**Consultation Response from KC,
Highways Development Management**

2026/90926 3, Lower Rotcher, Rotcher Lane, Slaithwaite, Huddersfield, HD7 5AZ

Erection of two storey and first floor side extensions and formation of parking area with associated works

Plan ref: Proposed Plans and Elevations

Title  
 Proposed layouts and elevations.

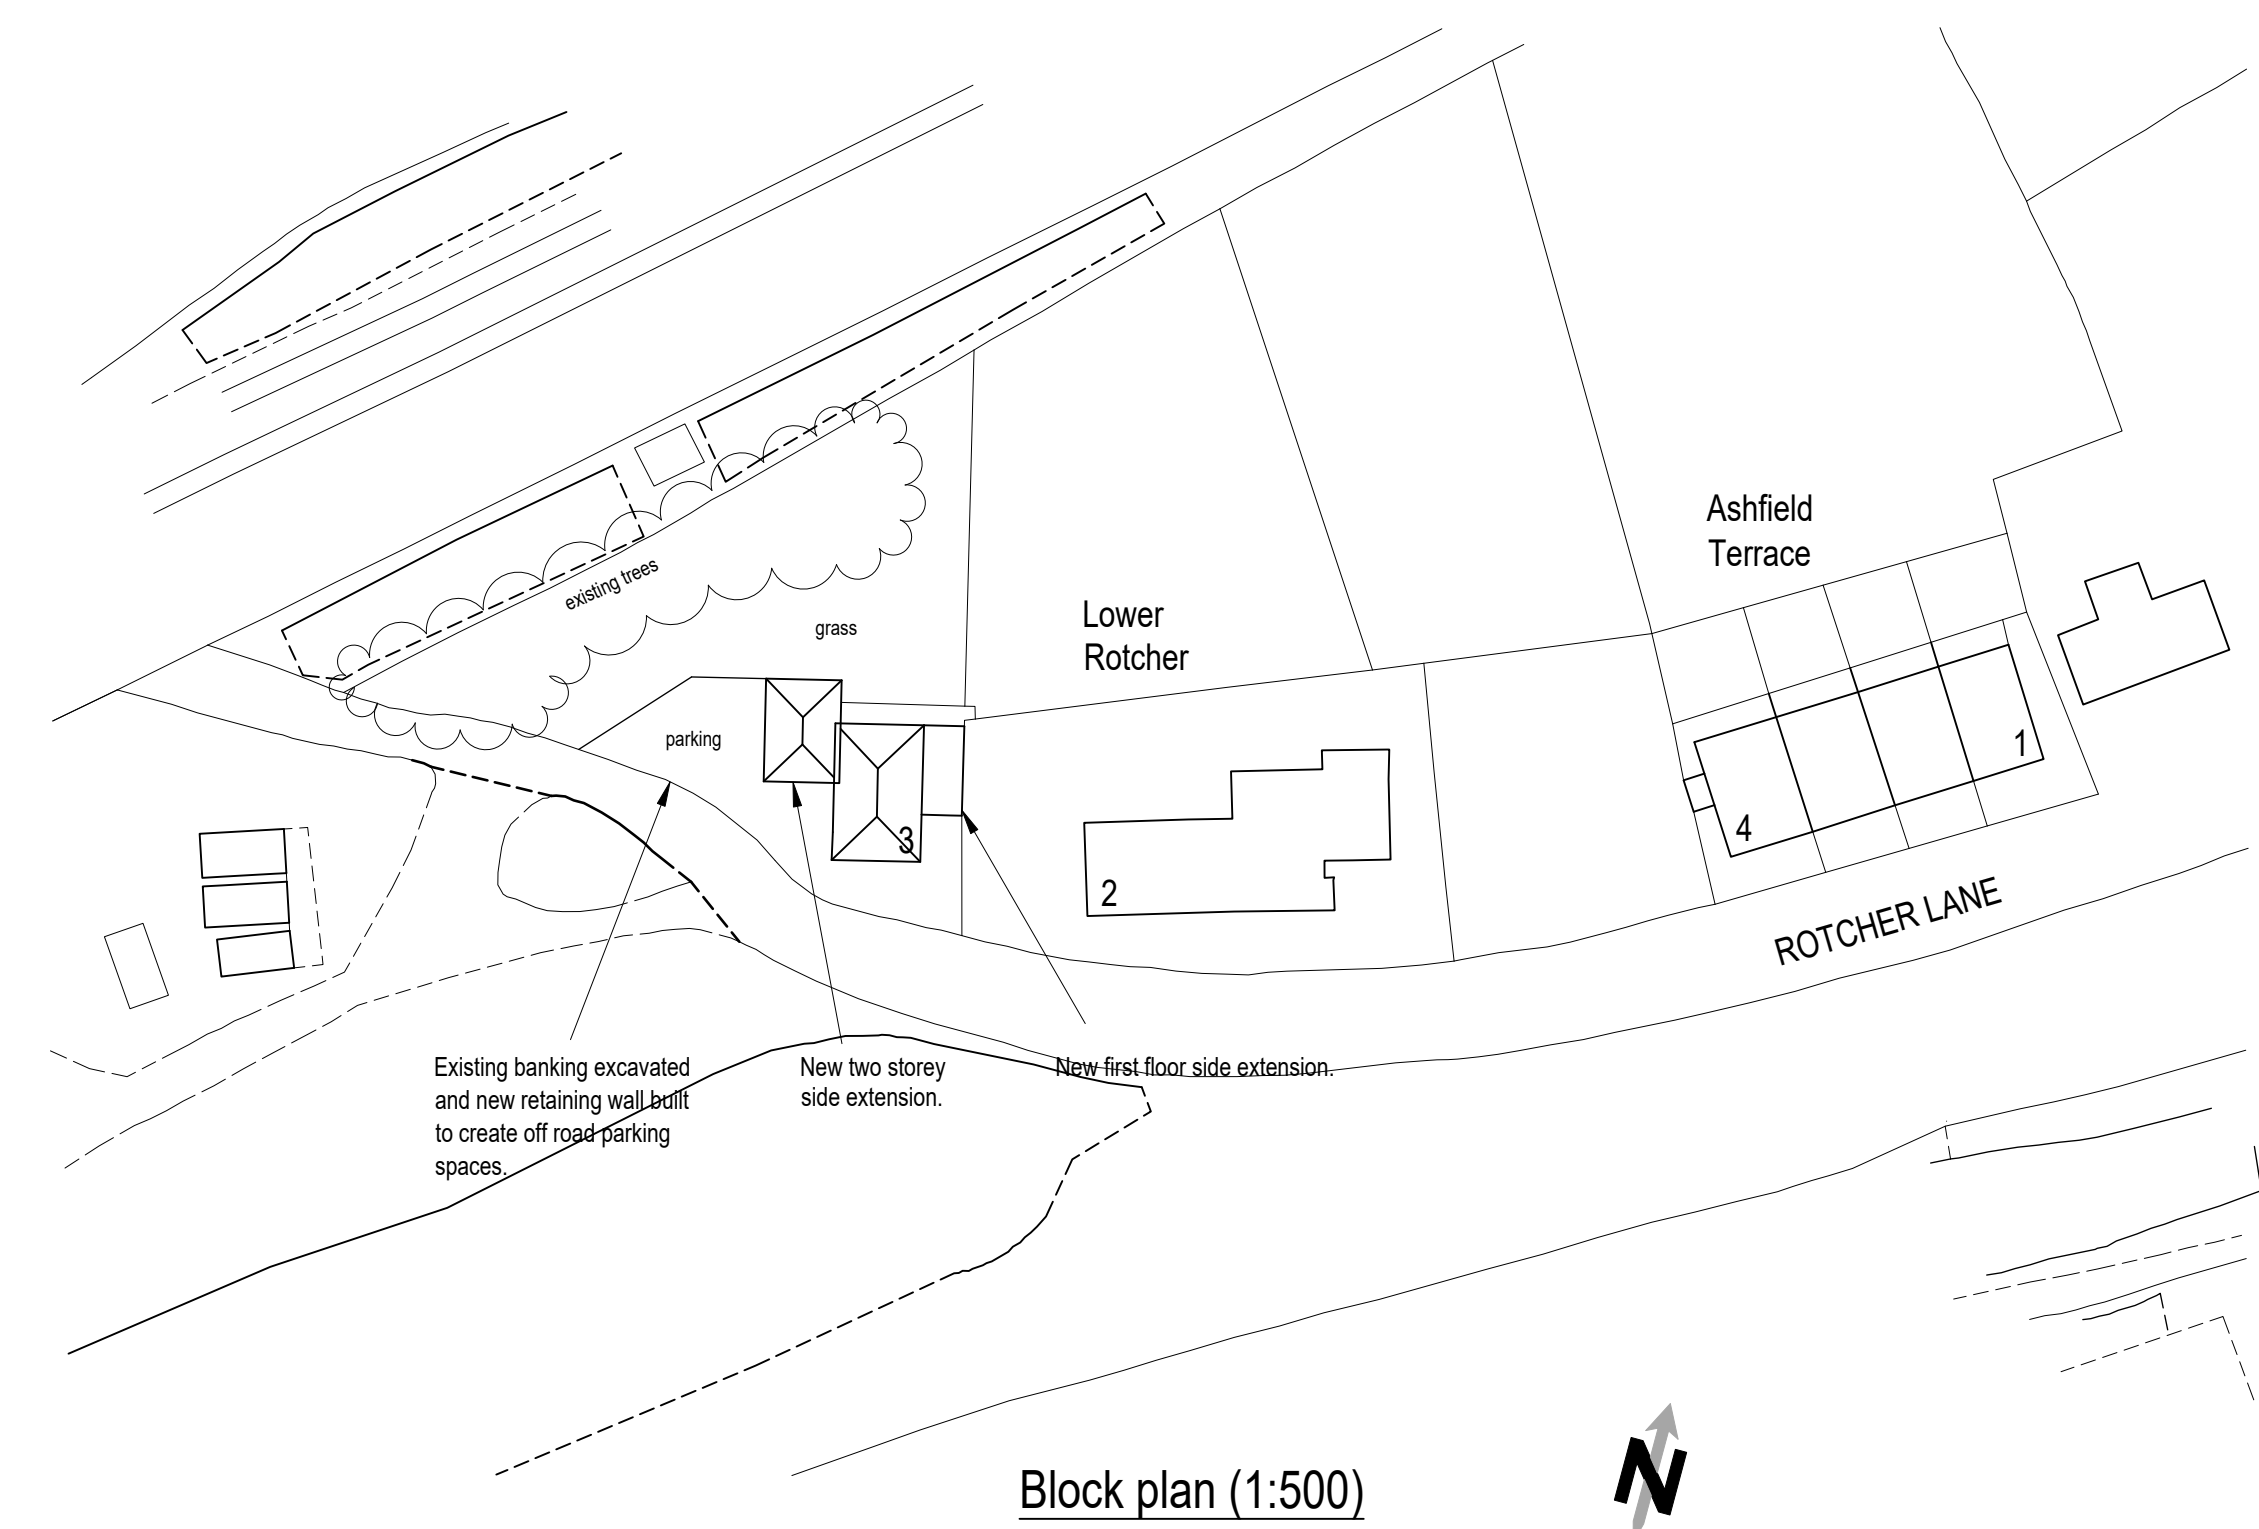
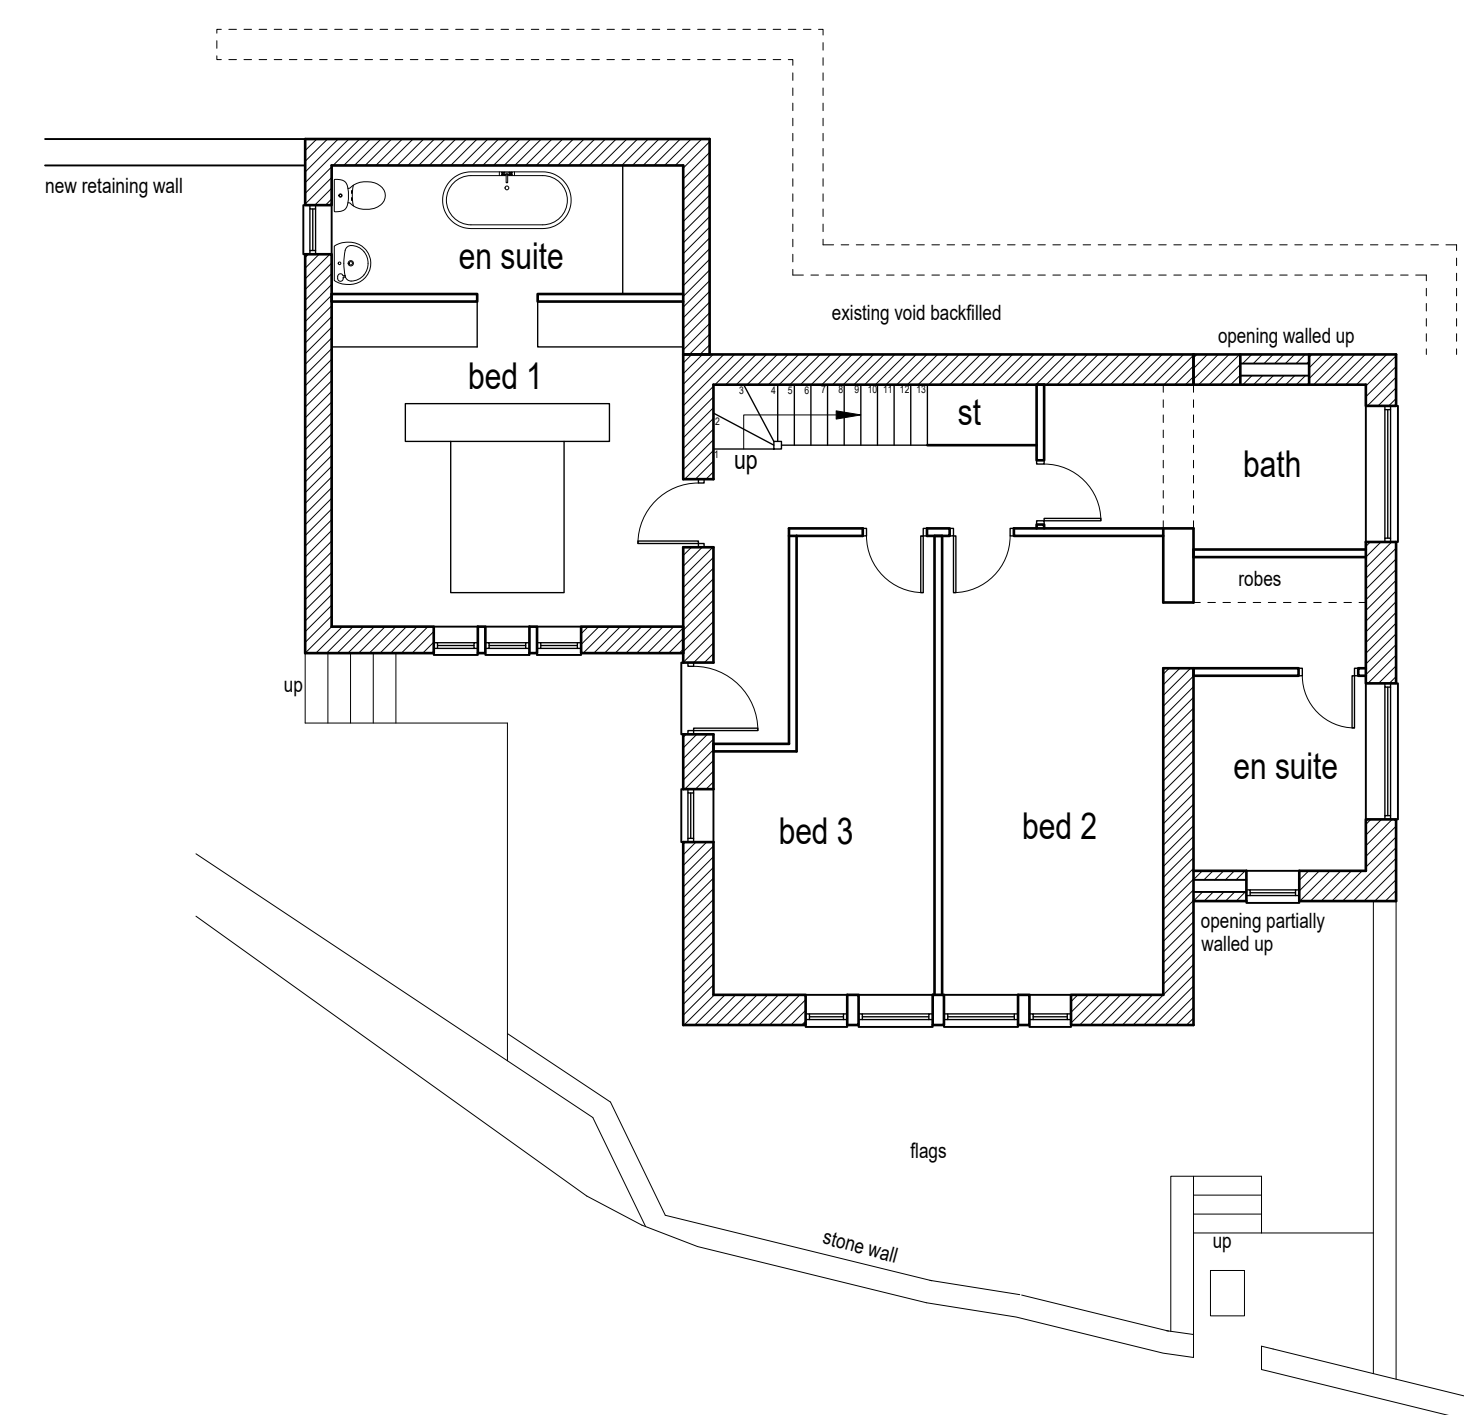
The proposal includes the creation of a new access from Rotcher Lane on removing the existing retaining wall and several trees and providing a new retaining wall after undertaking excavations. The new connection to the public road will require a separate permission from Highways including any relevant structural approval.

Within the site there is to be an area of hardstanding to accommodate off-street parking to serve the existing dwelling on completing the proposed extension.

There would be sufficient space to accommodate at least two cars in line with advice set out in the KHDG SPD for three bedroomed units and to meet policy LP22.

Hardstanding is to be in tarmac which is acceptable on it being permeable or surface water drainage will be needed to prevent run-off onto the highway.

- a) Means of Access: The means of access to and from the site shall be in accordance with the preliminary access design shown on the approved plan named Proposed Plans and Elevations and fully constructed and made operational prior to the development being brought into use and thereafter retained and maintained for the lifetime of the development.

- b) Retaining Walls: Before the development commences a scheme detailing the location and cross-sectional information together with the proposed design and construction details for all new retaining walls/ building retaining walls adjacent to the proposed adoptable/ existing highway together with any proposed modifications to existing highway retaining walls shall be submitted to and approved by the Highway Authority in writing. The approved scheme shall be implemented prior to the commencement of the proposed development and thereafter retained during the life of the development.

- c) Vehicle and Pedestrian Spaces to be Laid Out: No dwelling shall be occupied until all areas and associated features shown on the approved plans to be used by vehicles and pedestrians, including paths and parking areas have been laid out, surfaced and drained, such that loose materials and surface water does not discharge or transfer onto the adjacent highway, and shall thereafter be retained and maintained for the lifetime of the development.
